**Consultation Response from KC,
Highways Development Management****2024/93079 The Radcliffe, 444, Huddersfield Road, Mirfield, WF14 0EE****Change of use and alterations to care home unit 2 to form 10 self-contained apartments****Date Responded: 13-5-2025.****Responding Officer: Mark Berry****Responding Ref: 10-2NE-1.**

These proposals are for an annex of the Radcliffe Residential Home. It is proposed that the annex will be converted into 10 residential flats.

Figure 1:9 – Parking Layout Plan

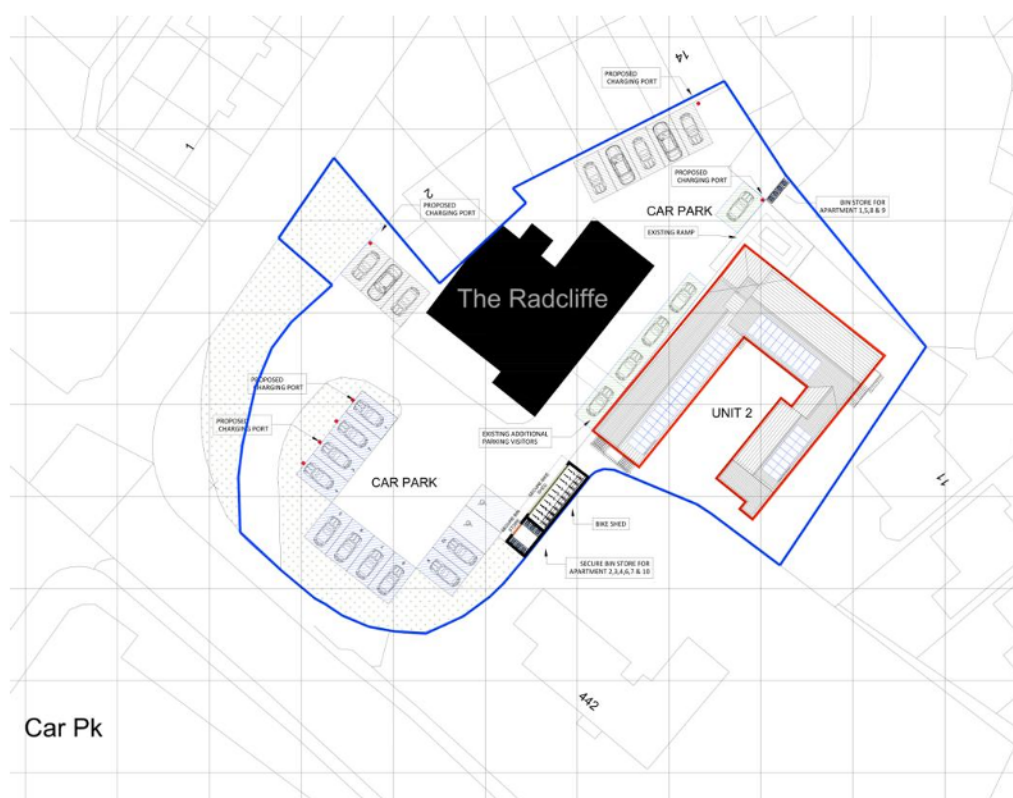
Poor forward visibility from the access road into the proposed car park area.

3, The number of parking spaces retained for the Care Home is just 9 spaces. No information is provided to demonstrate that this will be adequate.

5, No pedestrian access is shown to be provided yet 40 % of all trips associated with the flats are pedestrian based on the finding of the Transport Statement.

PROPOSED SITE LOCATION PLAN & CAR PARK LAYOUT PLAN SCALE 1:200 @ A1

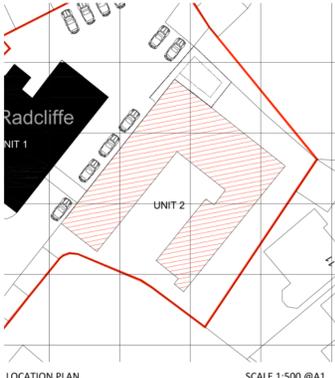
1, The existing access onto Huddersfield Road is severely sub-standard as follows.

Width (not wide enough to allow 2 vehicles to pass).

Sight lines from the access onto Huddersfield Road are poor to the east and over third-party land.

Conflicts and poor inter-visibility between the access with the adjacent driveway to Greenacres.

Conflicts with the junction of Huddersfield Road and Coppin Hall Lane.

4, The Transport Statement refers to servicing arrangements are to be the same as the existing care house use with no proposed changes, but no details are provided. Details of the collection of wastes from the site need to be provided. HDM would not wish to see bins presented on Huddersfield Road for collection.
